# Rezoning Transportation Analysis

Petition Number: 2020-197

Date	Description
12-28-2020	First Review (KP)

Pinecrest West

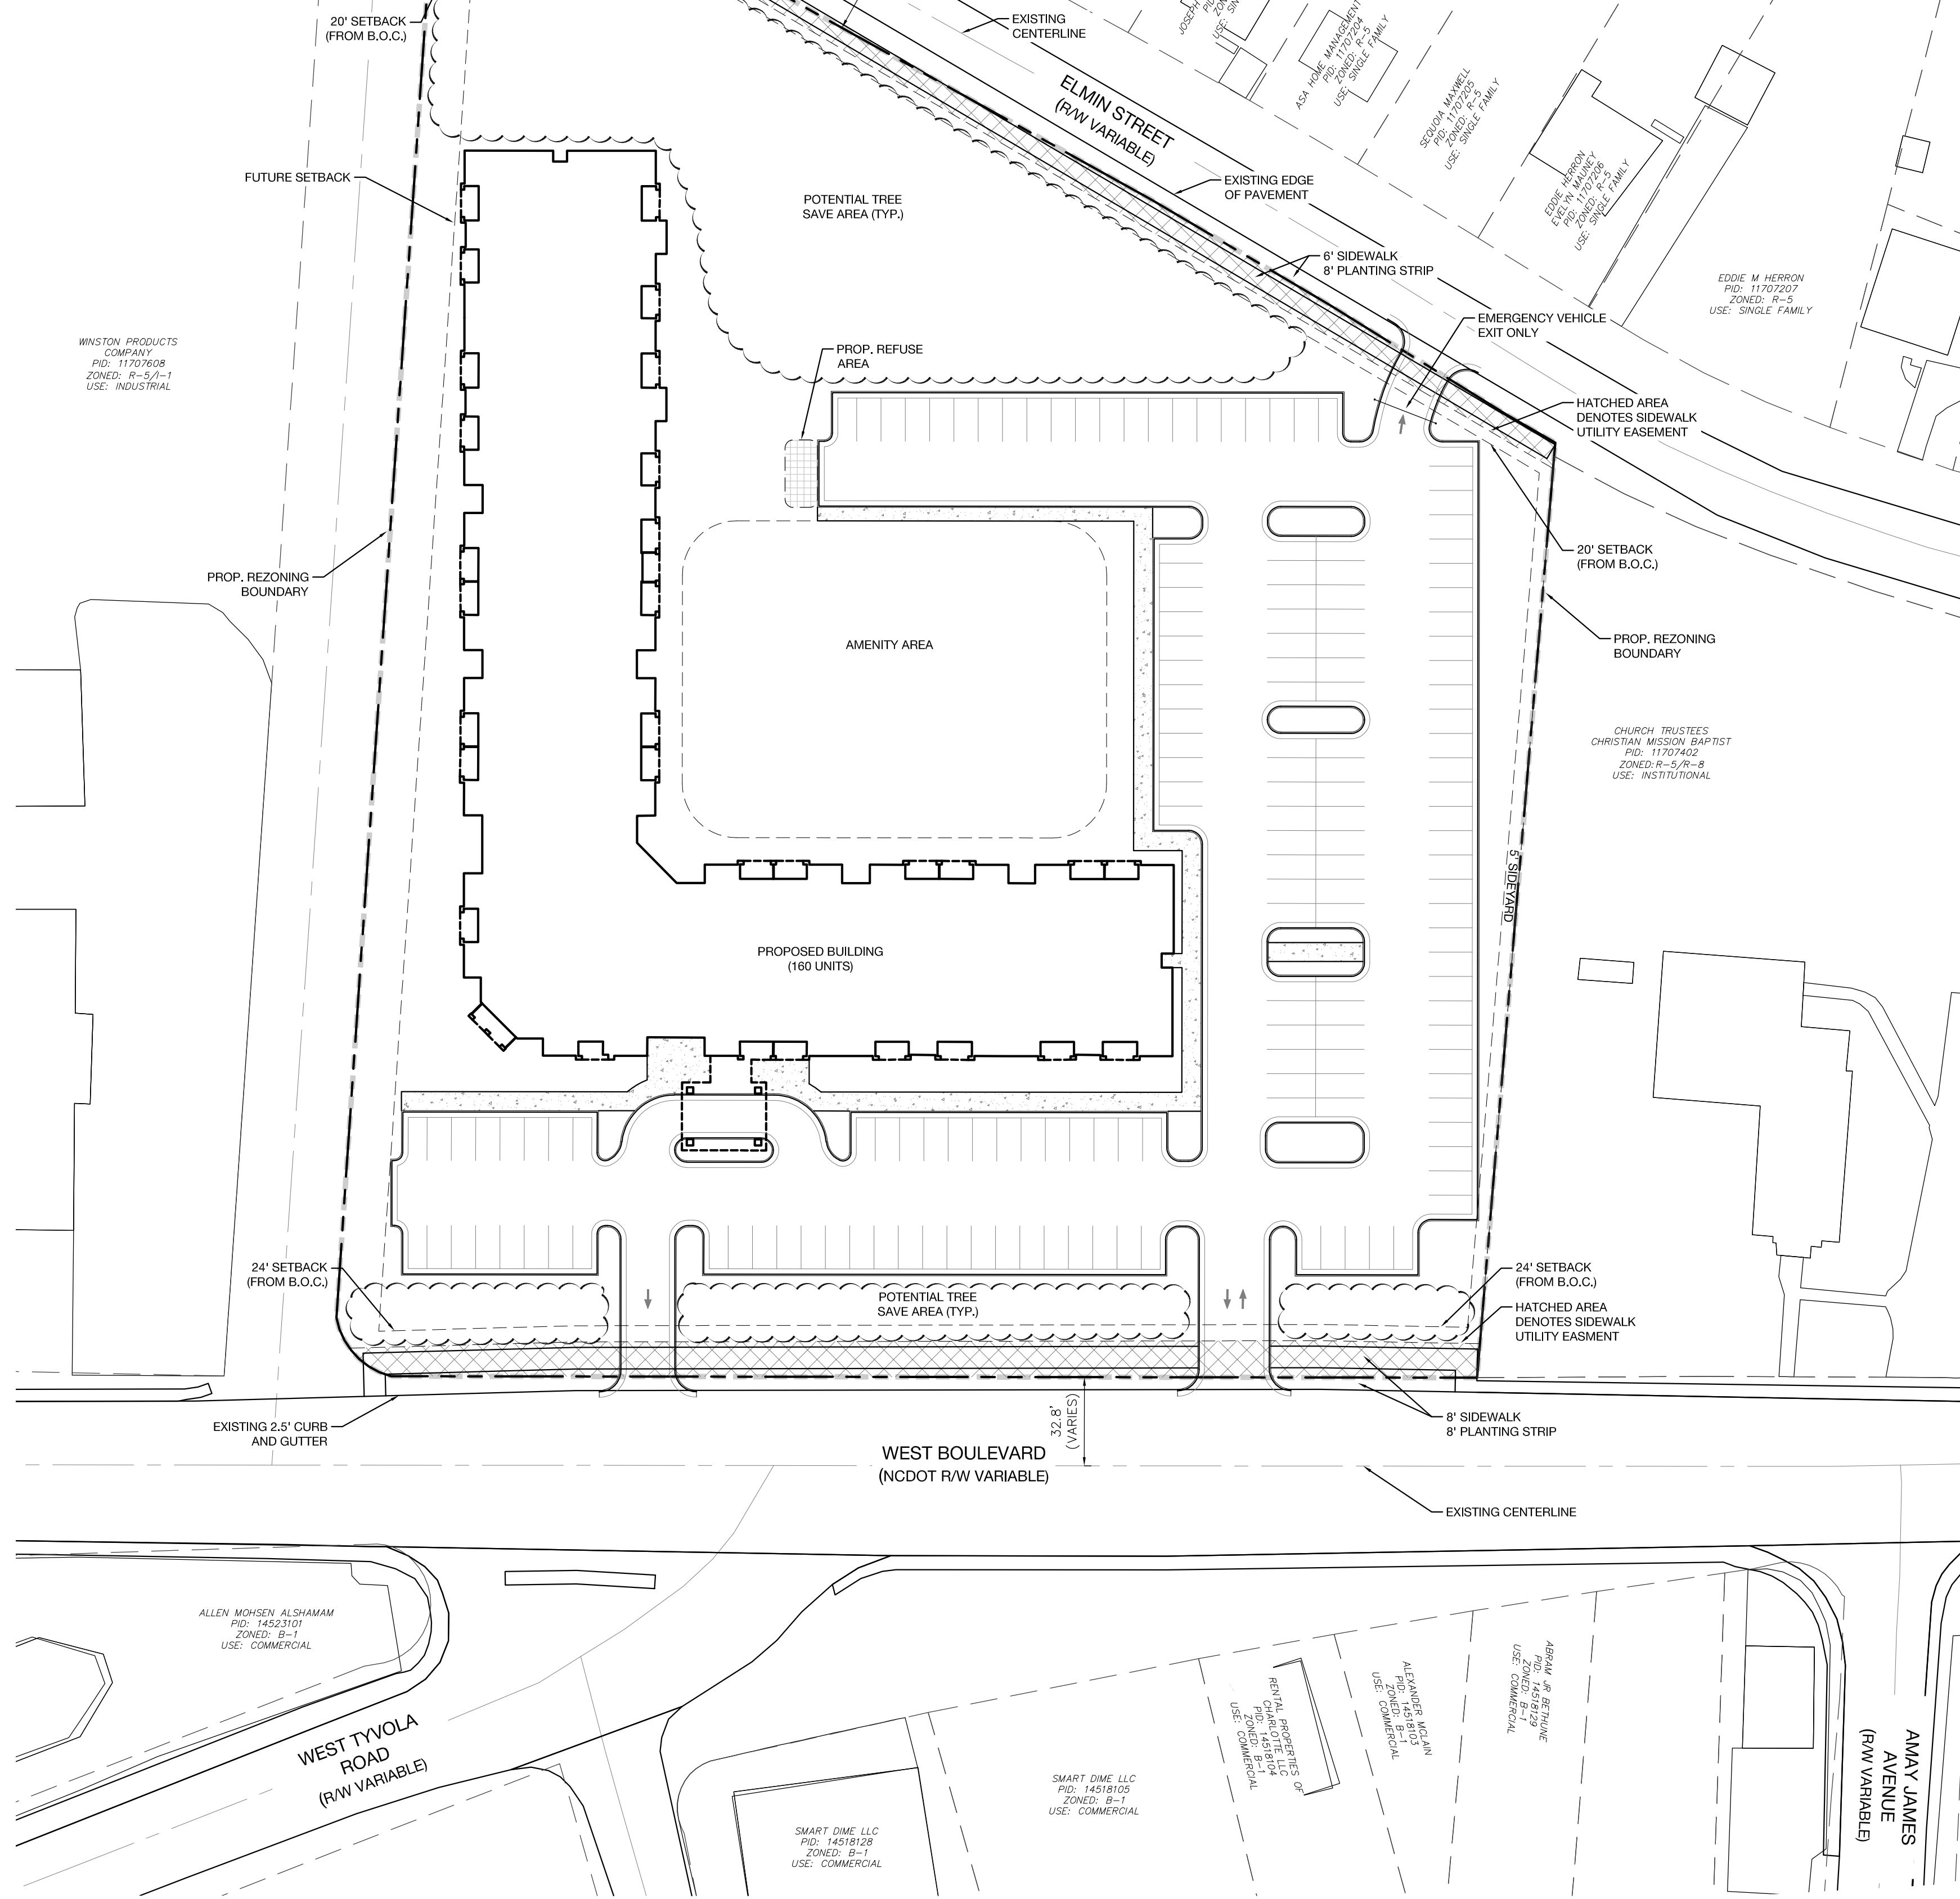
- a. **West Boulevard:** The future location of curb and gutter will be 38-feet from centerline to back of curb to accommodate a future 4-lane Avenue with separated bike lanes.
- b. **Elmin Street:** Location of curb and gutter will need to be constructed 17.5-feet from the centerline to back of curb, according to the City's Local Residential Wide (U-03A) street section.

Label and dimension the curb and gutter from the centerline for each road on the site plan.

- a. **West Boulevard:** Revise site plan and conditional note(s) to commit to dedicate 54-feet of right-of-way from the road centerline.
- b. **Elmin Street:** Revise the site plan and conditional notes to commit to dedicate 35.5-feet from the road centerline, in accordance with the City's Local Residential Wide (U-03A) street section.
- c. **Paper Right-of-way:** Revise the site plan and conditional notes to dedicate 28-feet of right-of-way from the existing paper right-of-way centerline, in accordance with the City's Local Residential Medium (U-02) street section.

Label and dimension the right-of-way from each road's centerline.

- 4. Revise site plan and conditional note(s) to commit to construct a 16-foot planting strip and 8-foot sidewalk along the site's frontage of West Boulevard, to accommodate for a future buffered bike lane, and an 8-foot planting strip and 6-foot sidewalk along Elmin Street and the developed portion of paper right-of-way. Label and dimension both items from the back of curb and gutter and road centerline.
- 5. Revise site plan by clearly labeling and dimensioning the paper right-of-way immediately to the west of the site.

- 6. Revise the site plan by including the existing infrastructure and striping for the center median and turn lane on West Boulevard and the channelized island at West Tyvola and West Boulevard.

- 7. Revise the site plan by creating a full movement (ingress and egress) driveway onto/from Elmin Street.

8. Revise the site plan and conditional notes by committing to constructing a curb ramp, in accordance with NCDOT Standards, at the corner of West Boulevard and the existing paper right-of-way adjacent to the site.

9. Revise site plan and conditional notes by removing the proposed driveways on West Boulevard and developing a portion of the existing paper right-of-way to provide access into the site. Additionally, the driveway at the paper right-of-way and West Boulevard will be a right-in right-out movement which will necessitate the extension of the existing center-lane median on West Boulevard, in accordance with NCDOT Standards. Lastly, the portion of developed paper right-of-way will be developed to the City's Local Residential Medium Section (U-02) and will include an 8-foot planting strip and 6-foot sidewalk along the east side (the site's frontage) of the developed paper right-of-way. This will also include a dead-end street barricade and marker in-line with CLDSM, at the street stub. The site plan should label and dimension each item from the road centerline.

10. Revise the site plan and conditional notes by committing to coordinate with CATS, during permitting, to make improvements to the existing bus stop on West Boulevard. The site plan needs to show the existing bus stop.

11. The site is located on a block length of 2,619 feet (see below blue line), from Old Steele Creek Road to Elmin Street. The proposed site's paper street is located approximately 1330 feet to the west of intersection of Old Steele Creek Road and West Boulevard. Since the UR-2 zoning district is being requested under this petition, please address Outstanding Issues 5 and 9, to promote walkability and connectivity, per the Urban Street Design Guidelines.

12. Revise the site plan and conditional notes by removing note 3.D from the conditional notes.
